TREE WORK ASSESSMENT

TPO: SHIREBURNE PARK

APPLICATION NO: 3/2026/0349

TREE 1 YEW.

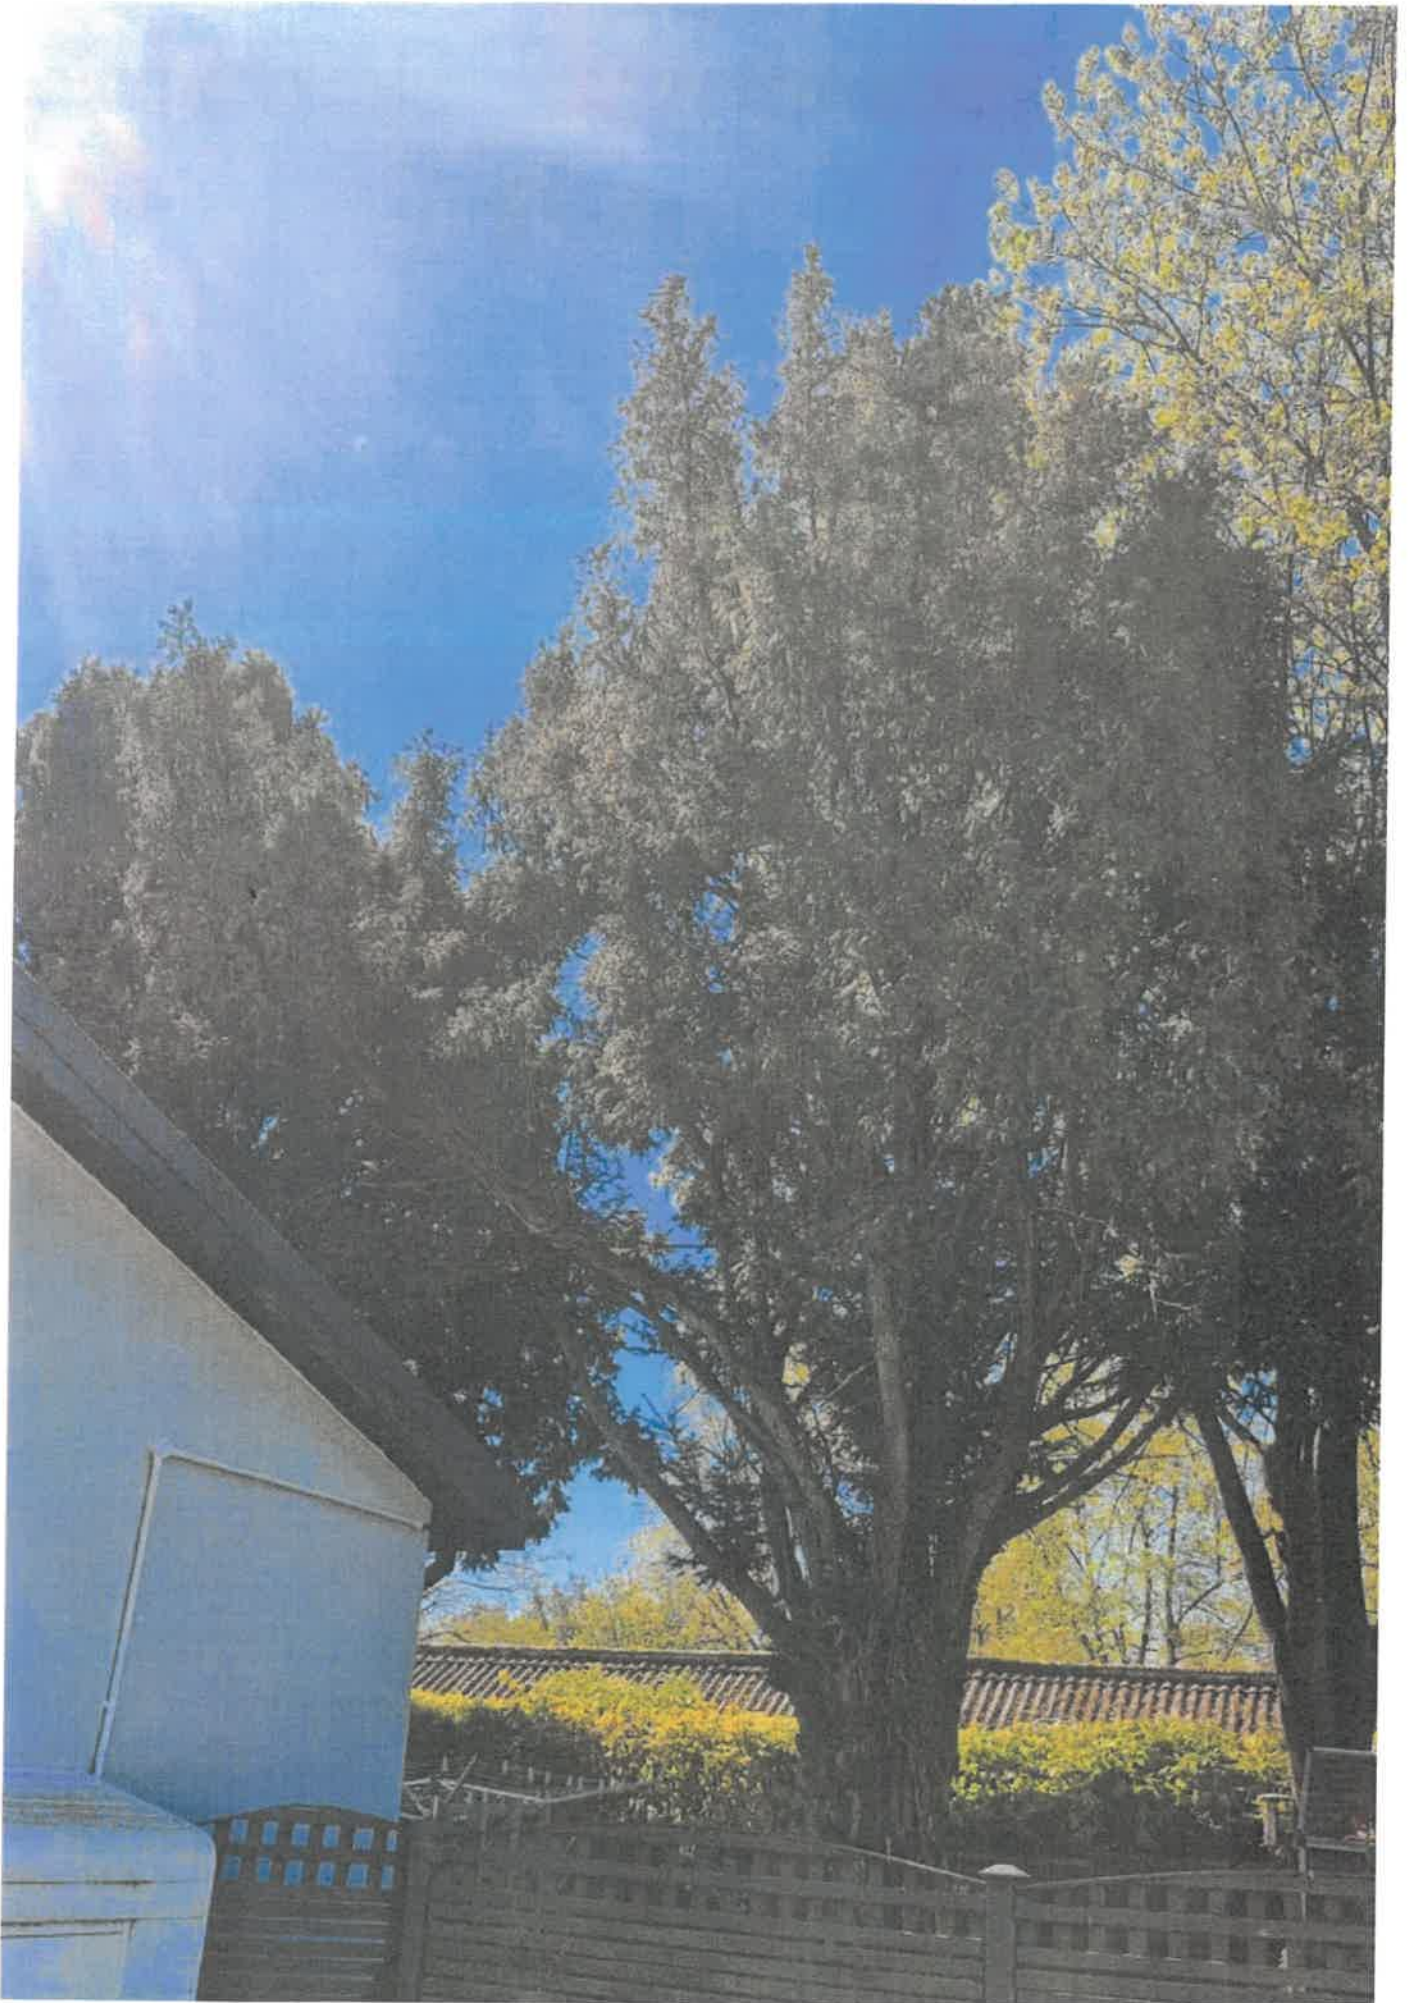
The pruning will reduce spread, retain an unformal appearance and reduce risk of failure over major target area the result will also generate natural crown regeneration that will become established in a relative short period of time

To reduce risk of tree failure
